From: Martyn White <Martyn.White@arun.gov.uk>
Sent: 14 August 2020 17:38
To: Amy Myer <Amy.Myer@arun.gov.uk>
Subject: LU/163/20/PL

LU/163/20/PL

6 Selborne Place, Selborne Road, Littlehampton BN17 5NH

Demolition of existing conservatory, single storey front & rear extensions & change of use from HMO (Sui Generis) to 5 No. flats (4 net) (C3 Dwelling house).

drawing title
Proposed Plans
-
PLANNING

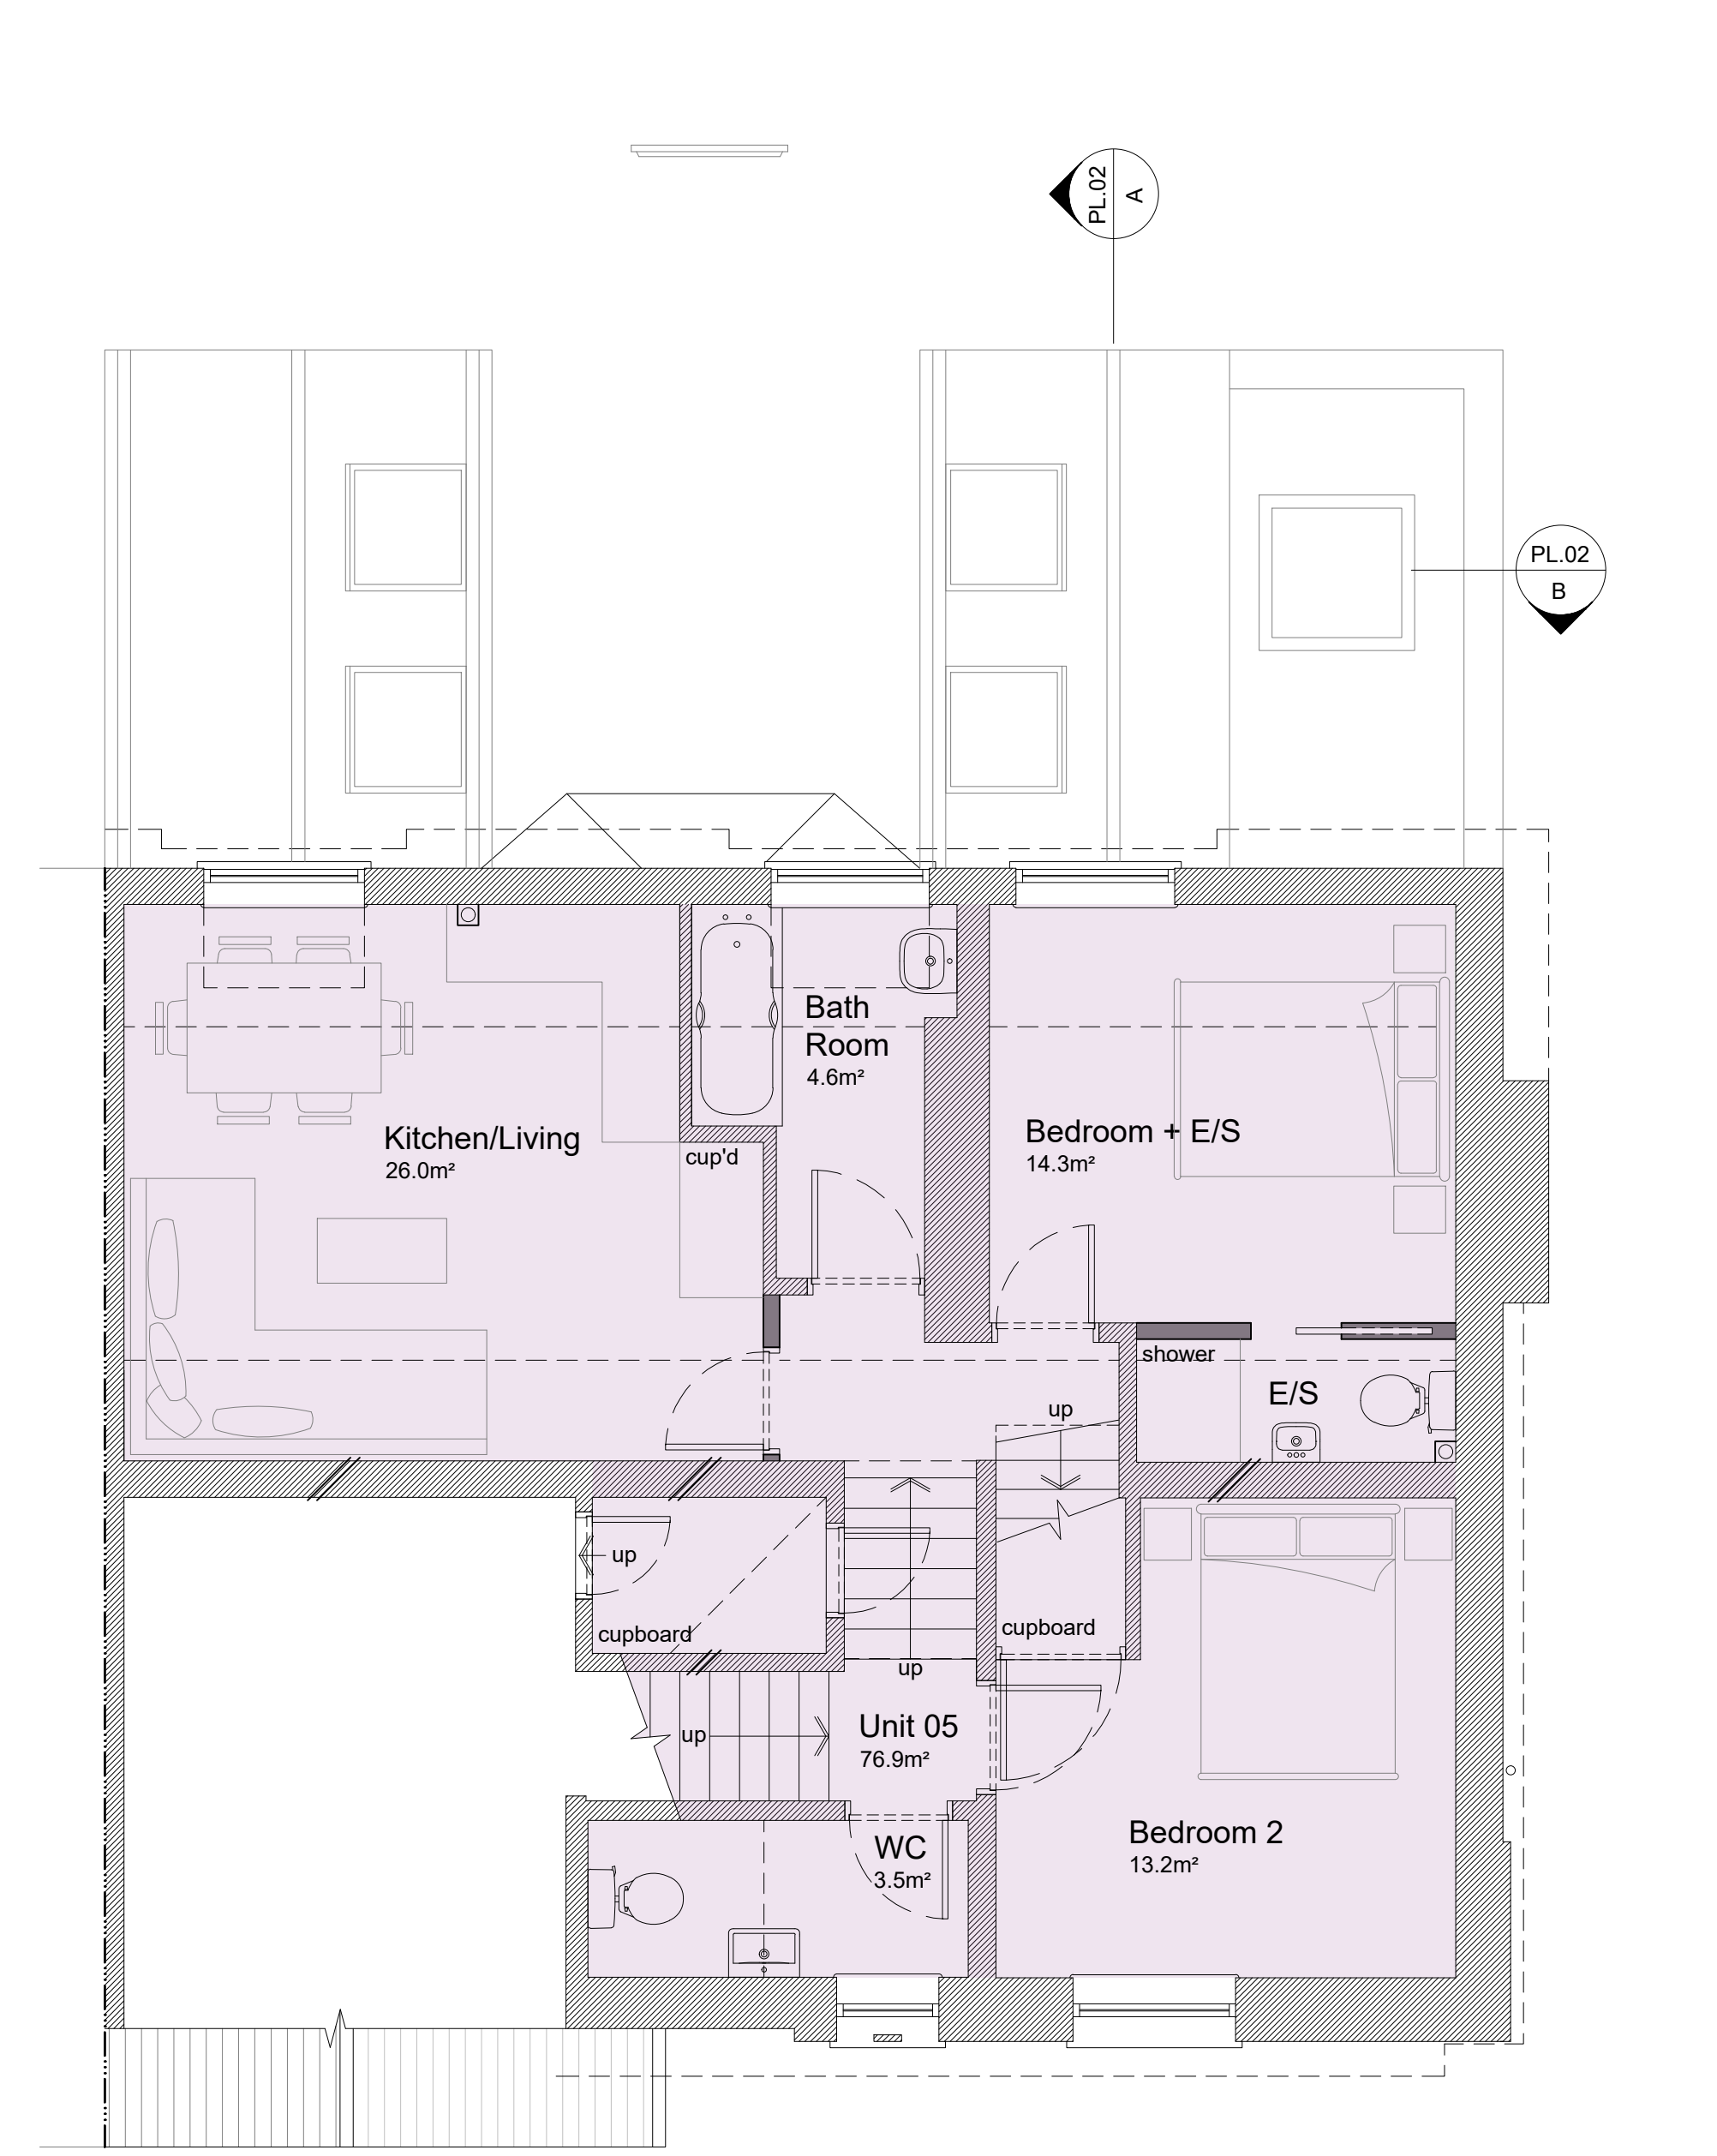
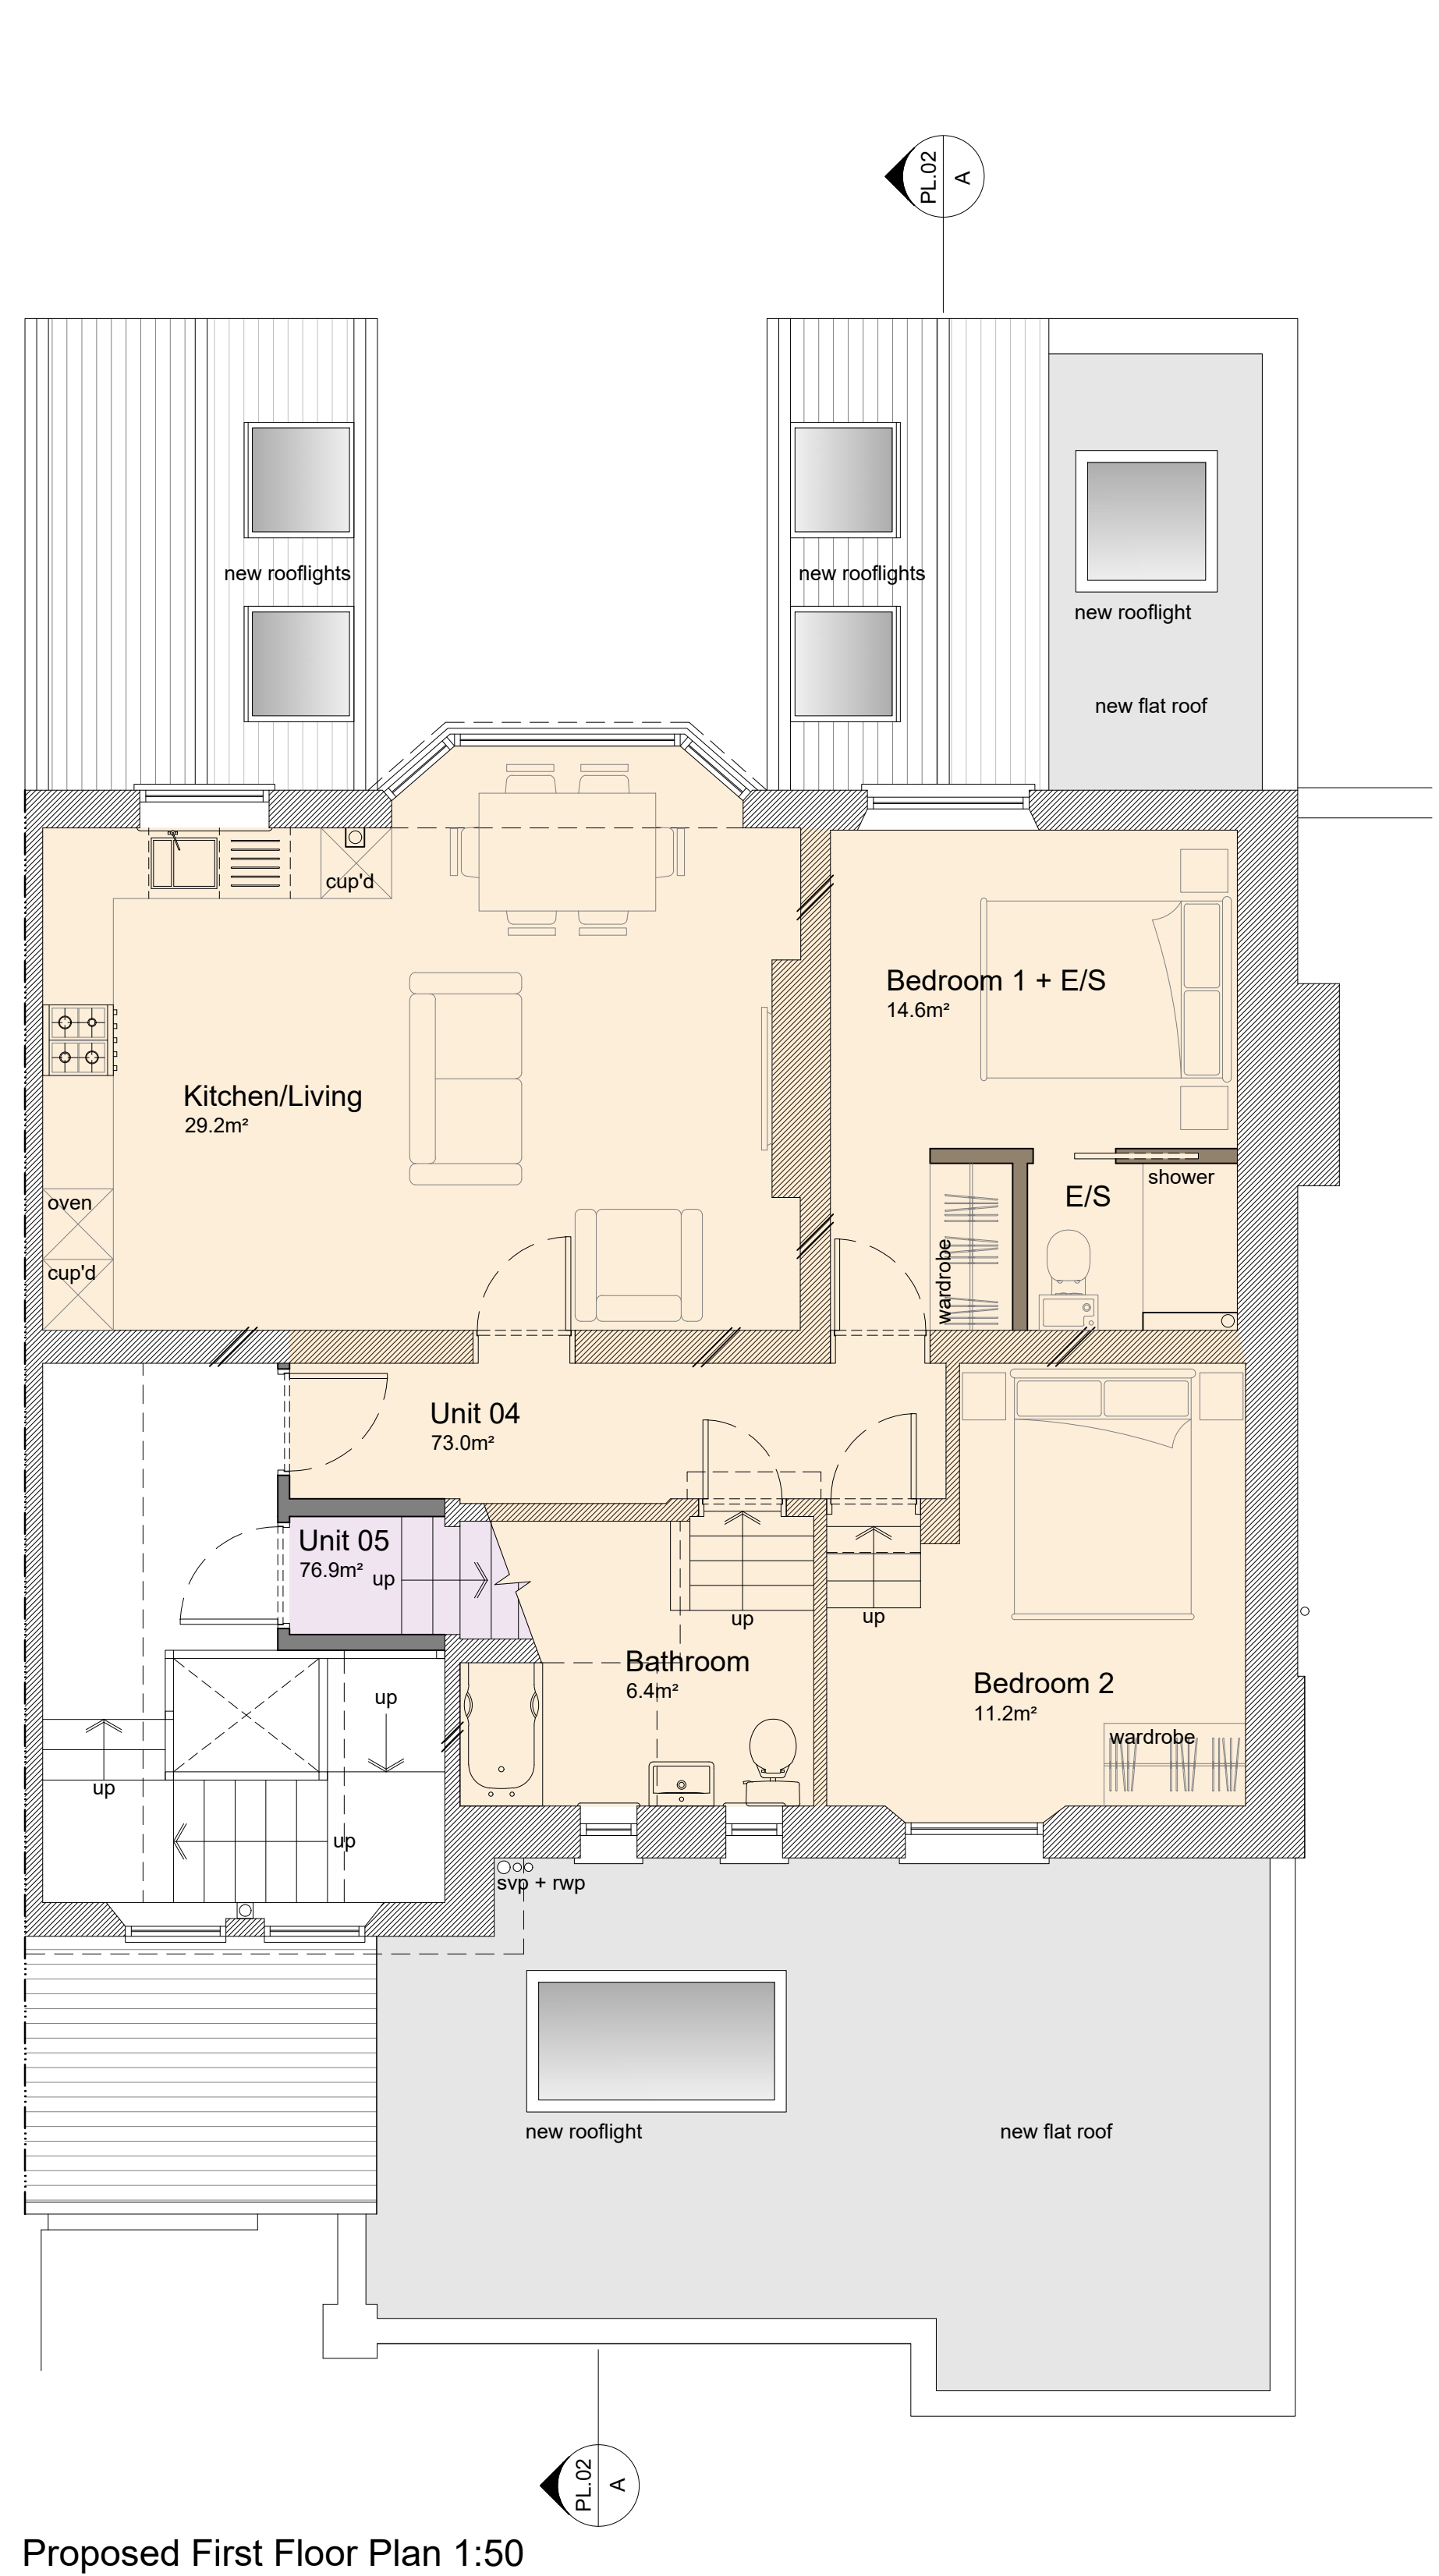
The proposed front extension will not be a prominent addition due to the fact that it is utilising the exiting courtyard area. Whilst the loss of the modern conservatory is a positive feature of the proposal, the new extensions will be more prominent, which will interfere with the original rear elevation of the building. This is unfortunate, and harmful. It is also suggested that proposals such as this should look for opportunities to enhance or better reveal their significance i.e. the use of more appropriate joinery; it is not clear if that is the case here.

The retention of the existing honeycomb detailing as part of the front extension is positive, and supported. Details of how the existing clay honeycomb walling will be kept and preserved as part of the creation of the north extension should also be considered so that they are not harmed.
